**Response to Notification of S96(1A) Application - SSD 6387 MOD 4
1 Burroway Road, Wentworth Point**

I refer to the Department's email correspondence dated 5 September 2016 inviting comments from SOPA in relation to the proposed modification of SSD 6387 which comprises:

- installation of a canopy over the central plaza area; and
- the inclusion of a 50m² café tenancy at the southern end of the through-site link.

Project Title
JEWEL RETAIL
1 BURROWAY RD, WENTWORTH POINT, THE WHARF SITE.
SYDNEY OLIMPIC PARK
Drawing Title
CAFE DESIGN

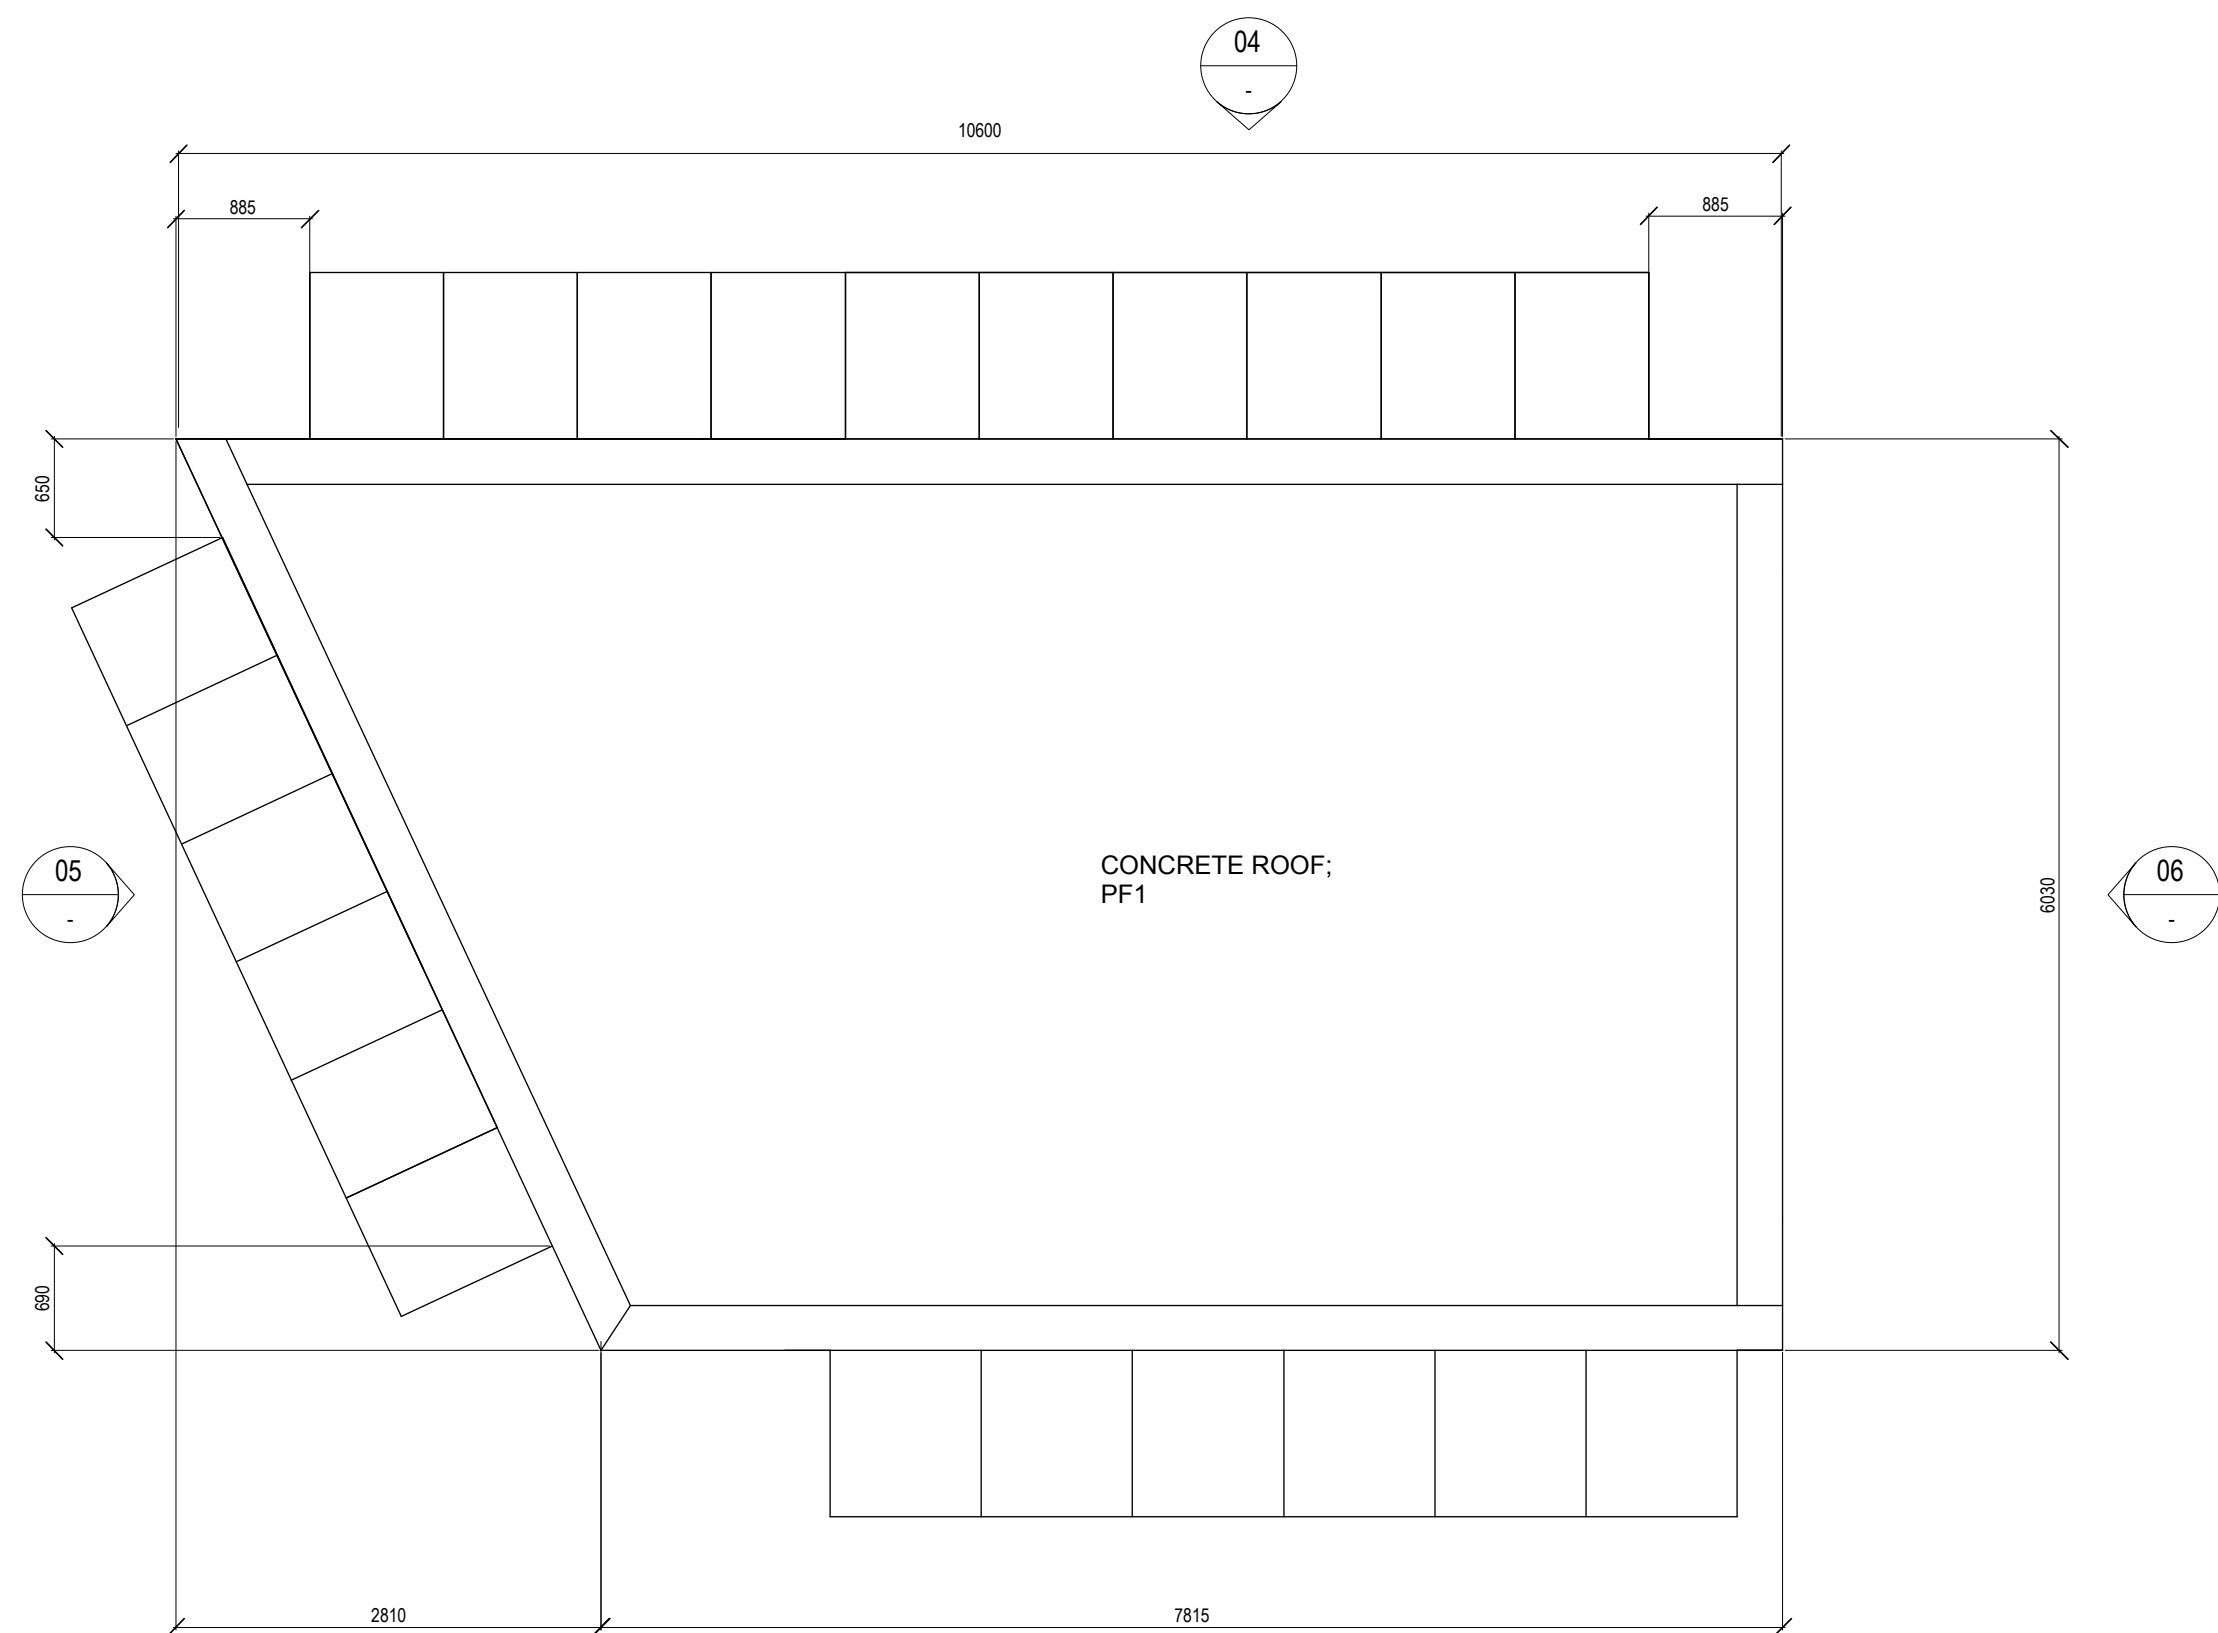
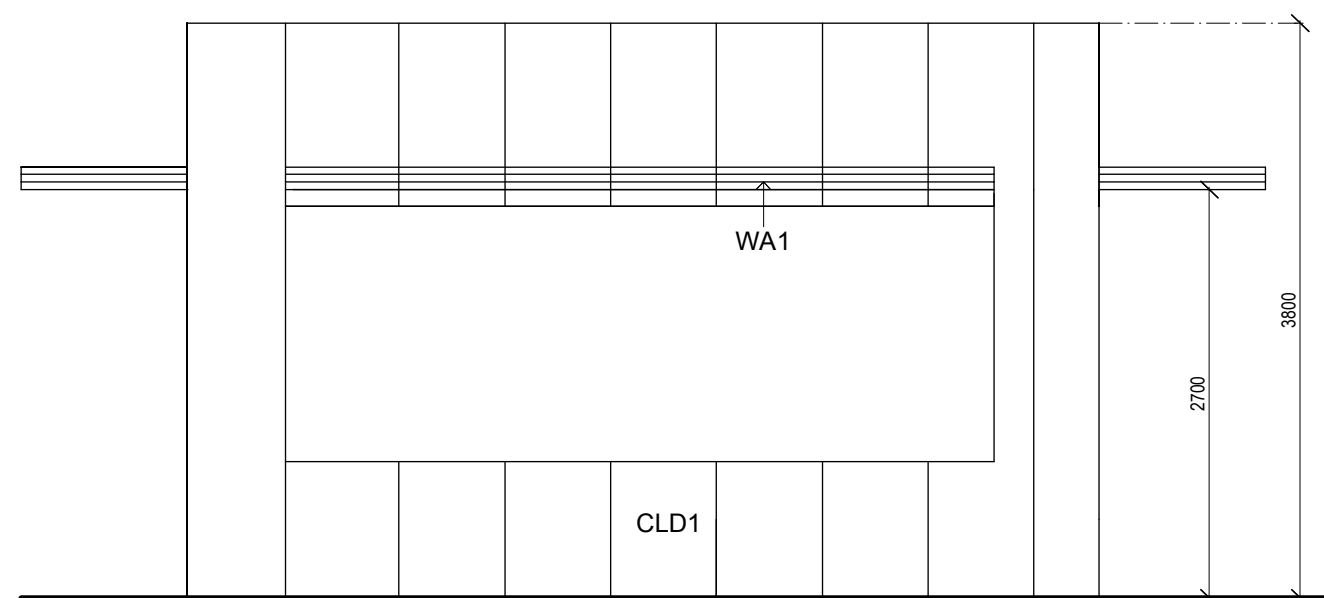
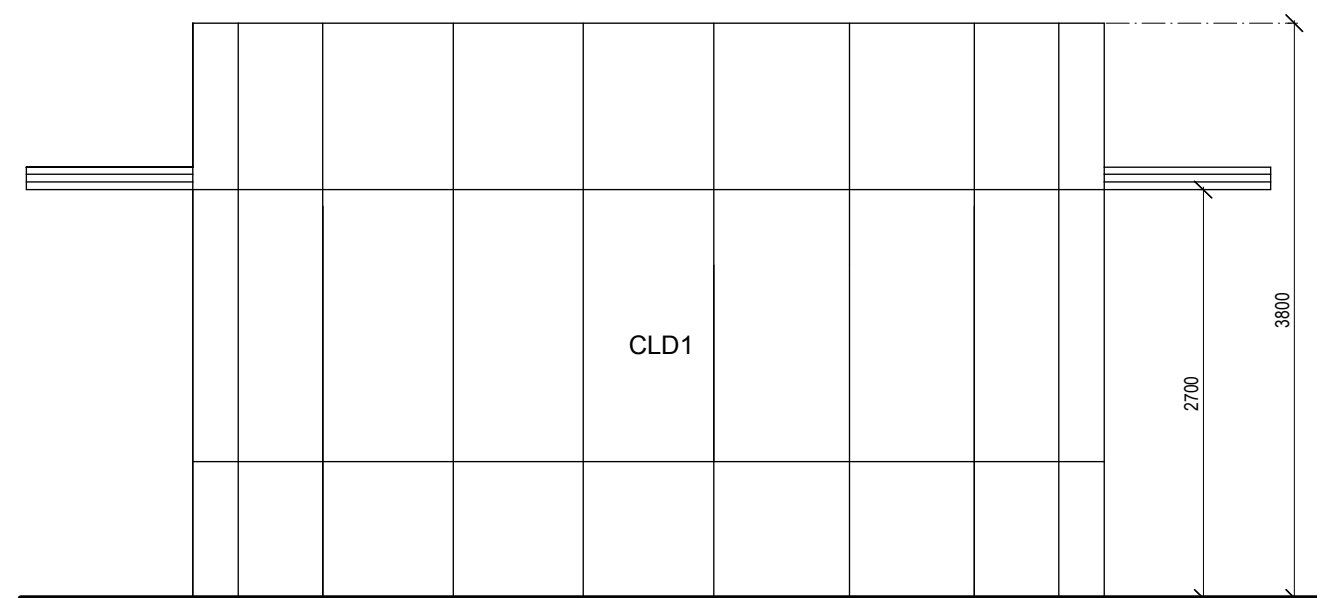
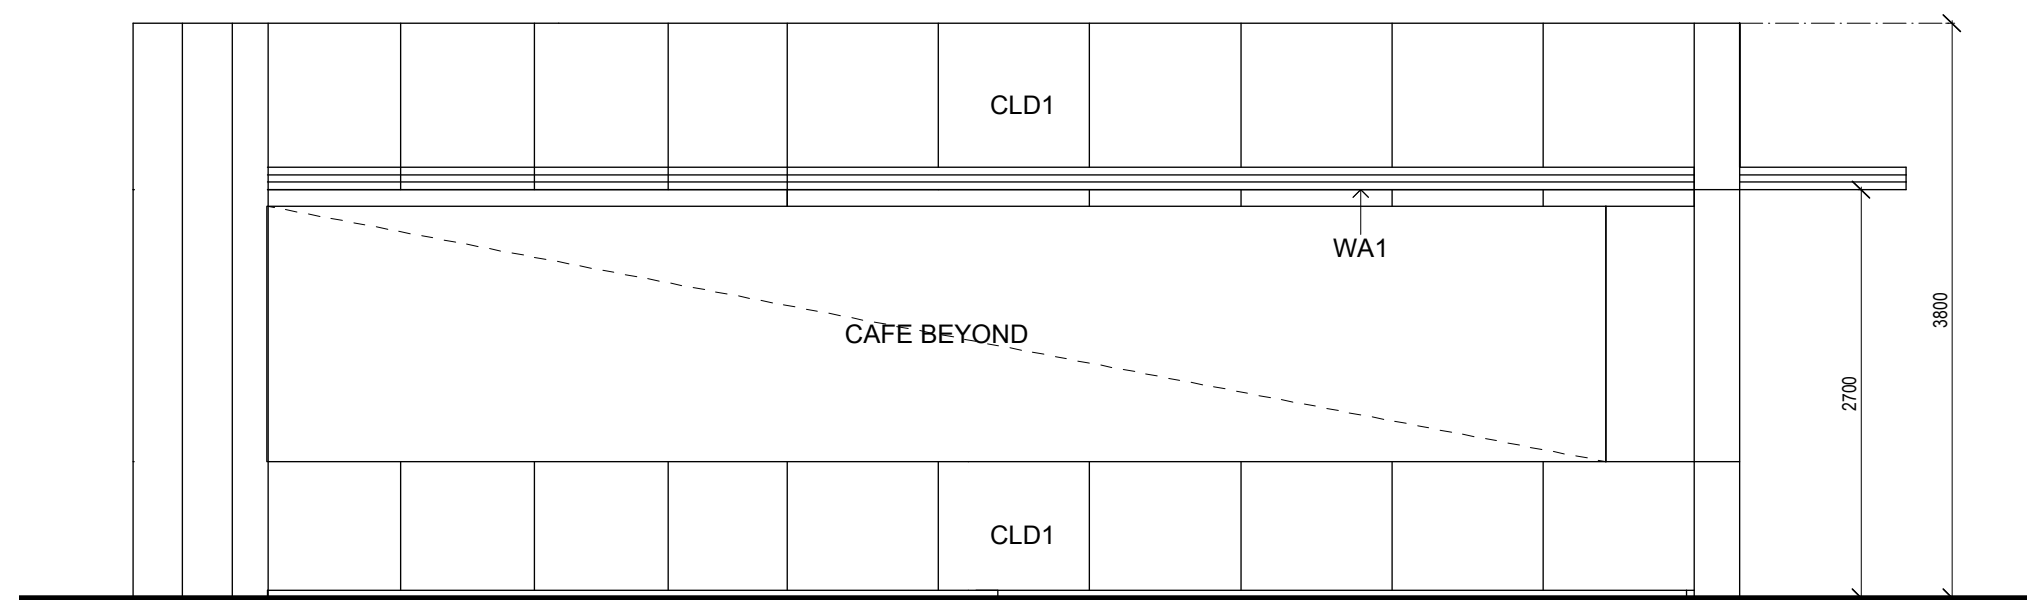
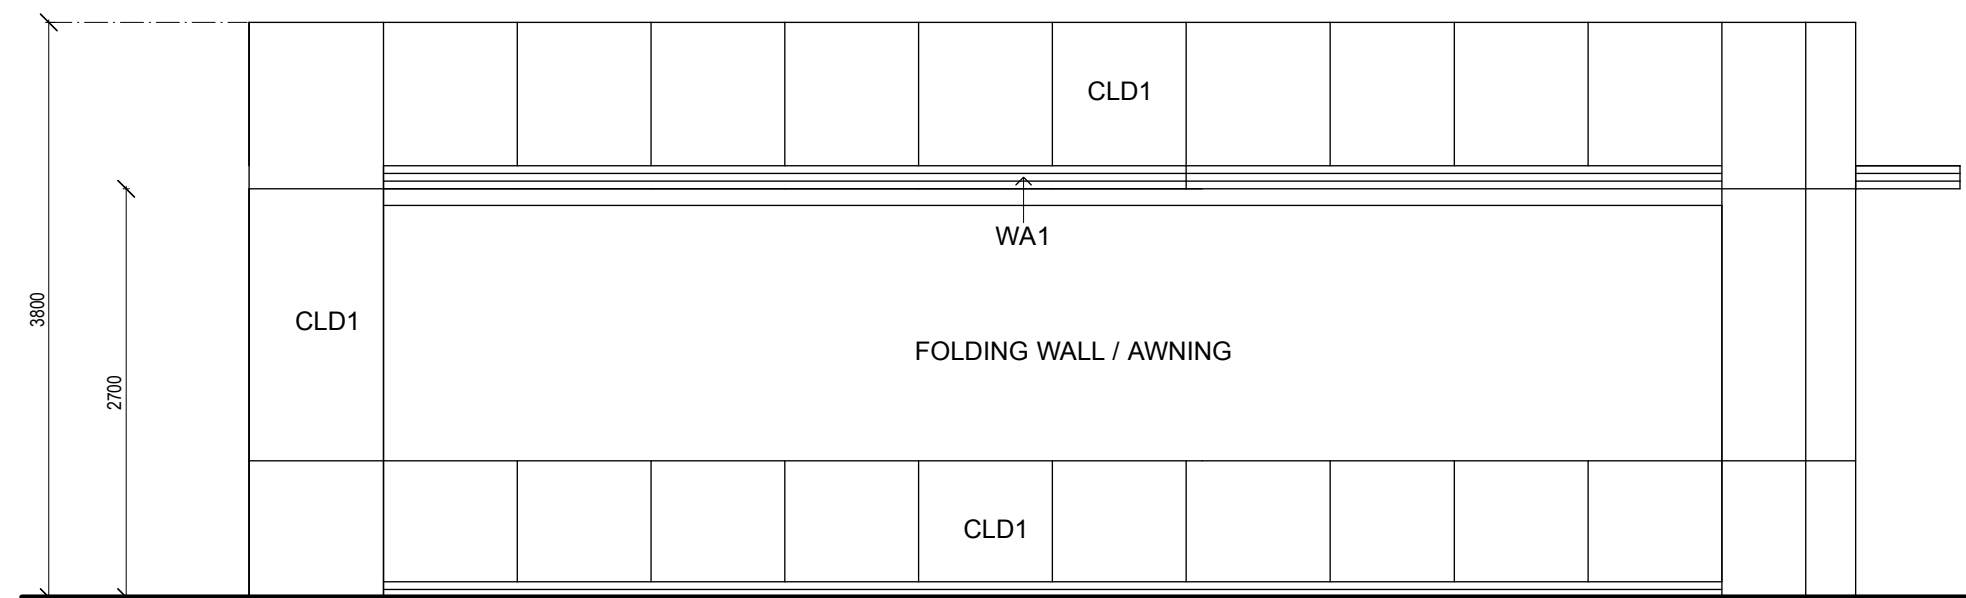
- the proposed location of the café is not consistent with the intent of the Through Site Link. The café should be set back to align with the western retail frontage to maintain a clear 13m width for the full length of the space; and
- the current proportions of the proposed café are considered to be excessive and should be reduced to a maximum area of 20m².

Further information is also required in relation to servicing (deliveries and collection of waste) the proposed café tenancy.

Project Title  
**JEWEL RETAIL**  
1 BURROWAY RD. WENTWORTH POINT, THE WHARF SITE.  
SYDNEY OLYMPIC PARK  
Drawing Title  
**ROOF PLAN & SECTION**

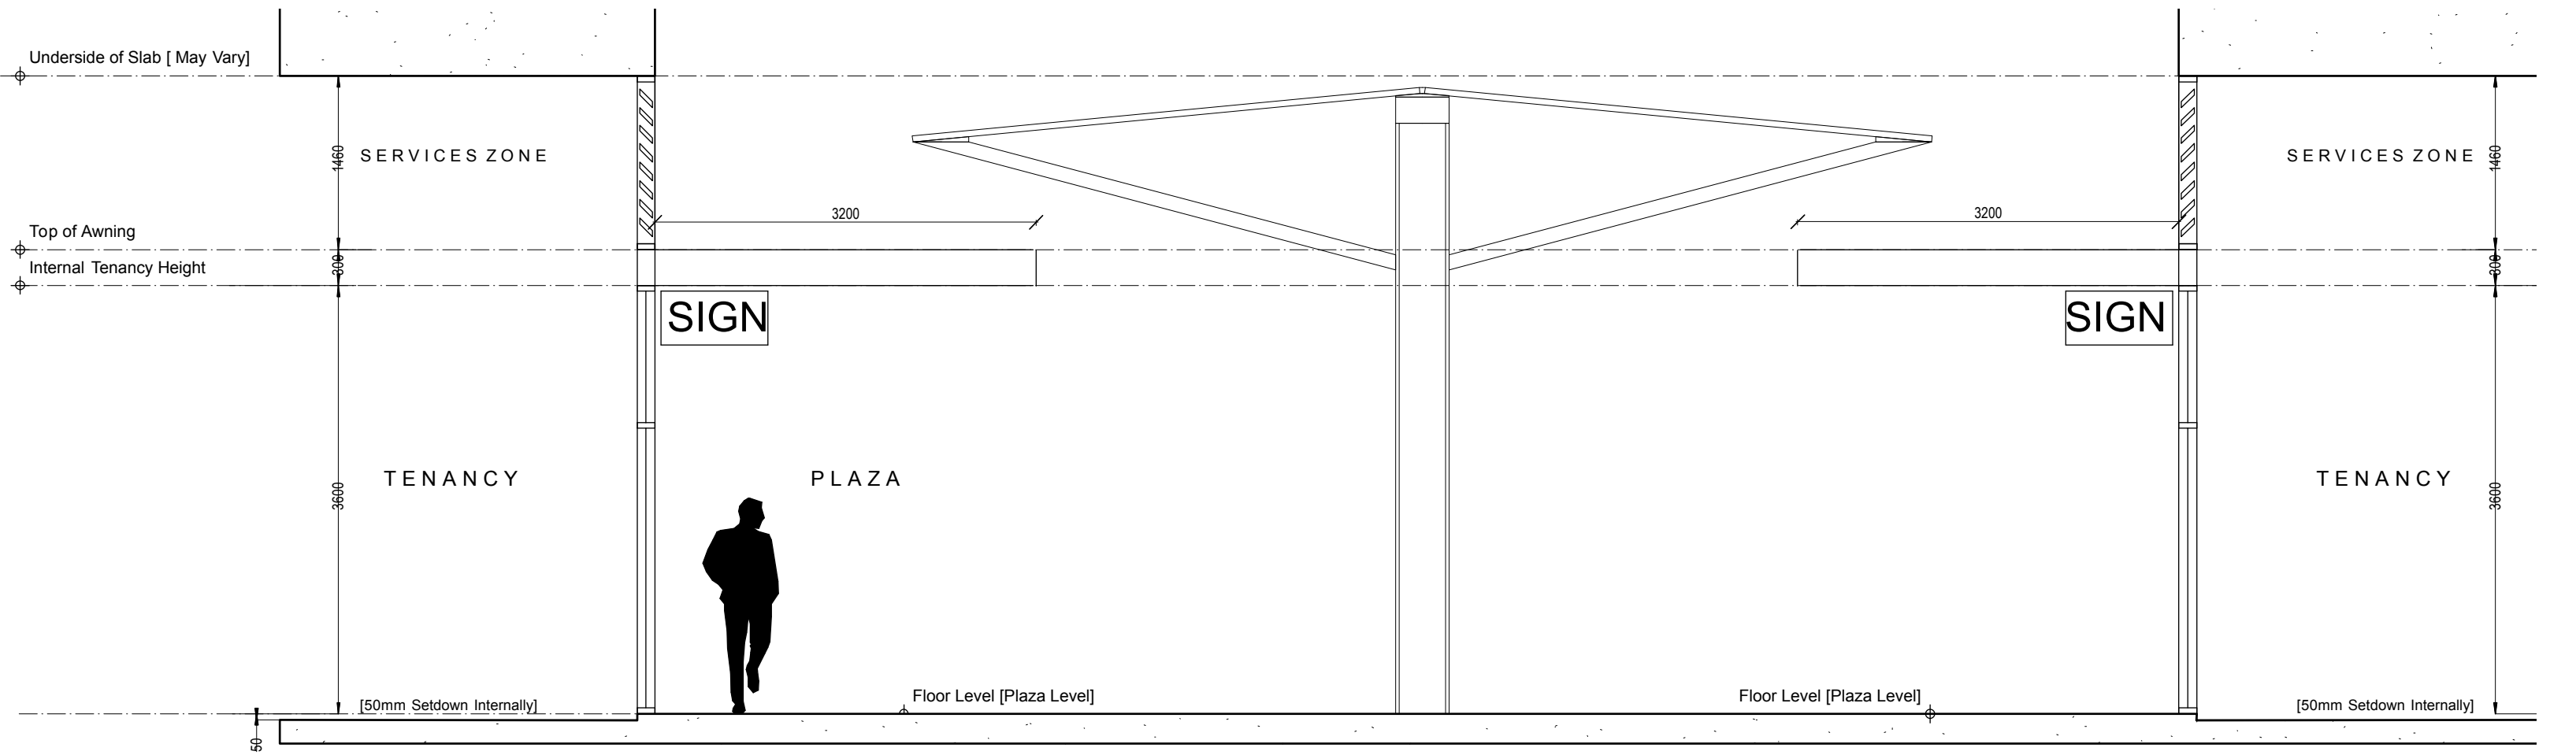
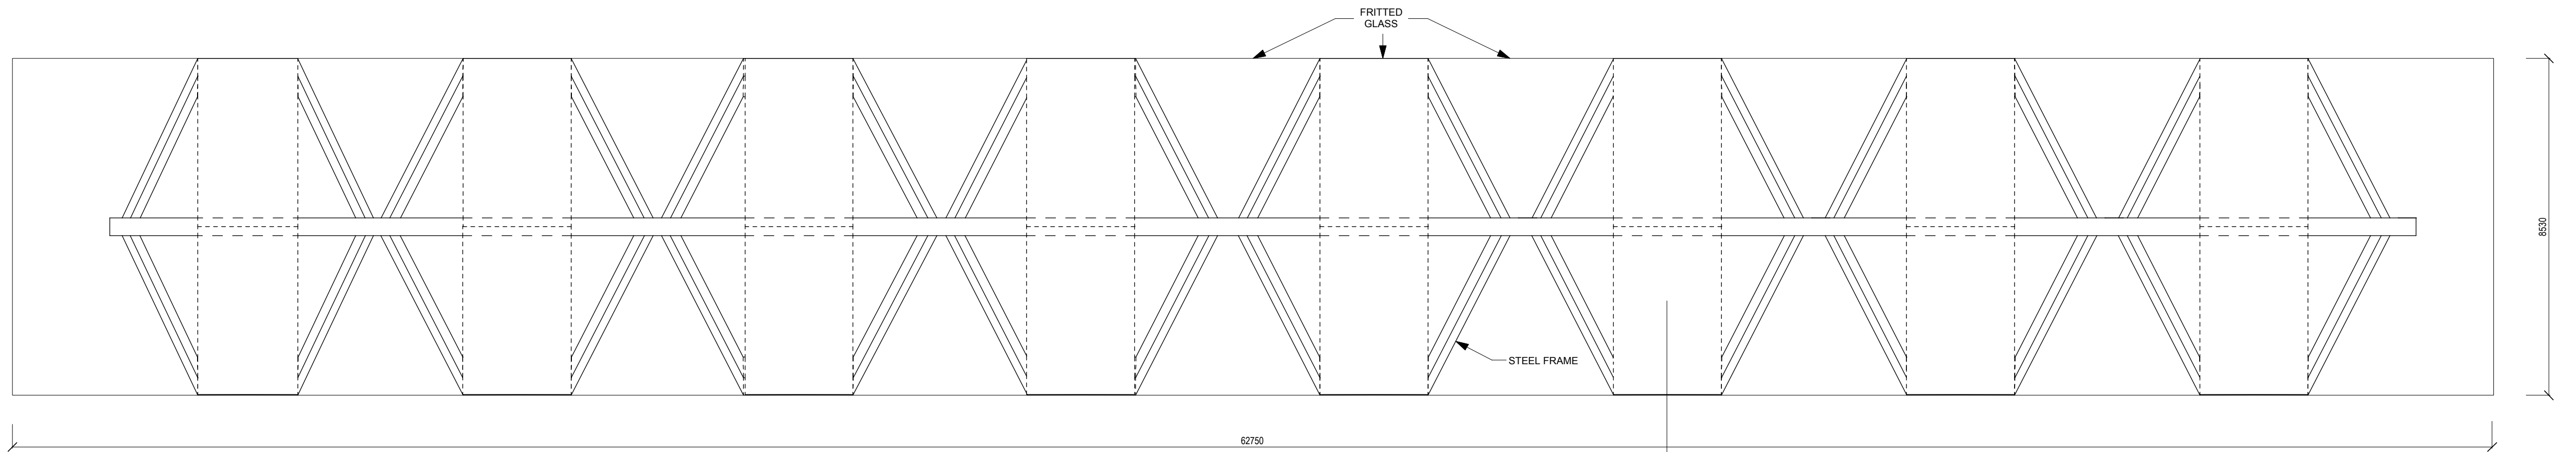
No information is provided in relation to management of stormwater off the canopy. If stormwater is intended to run off the canopy to the adjacent awnings, said awnings must be designed accommodate additional water.
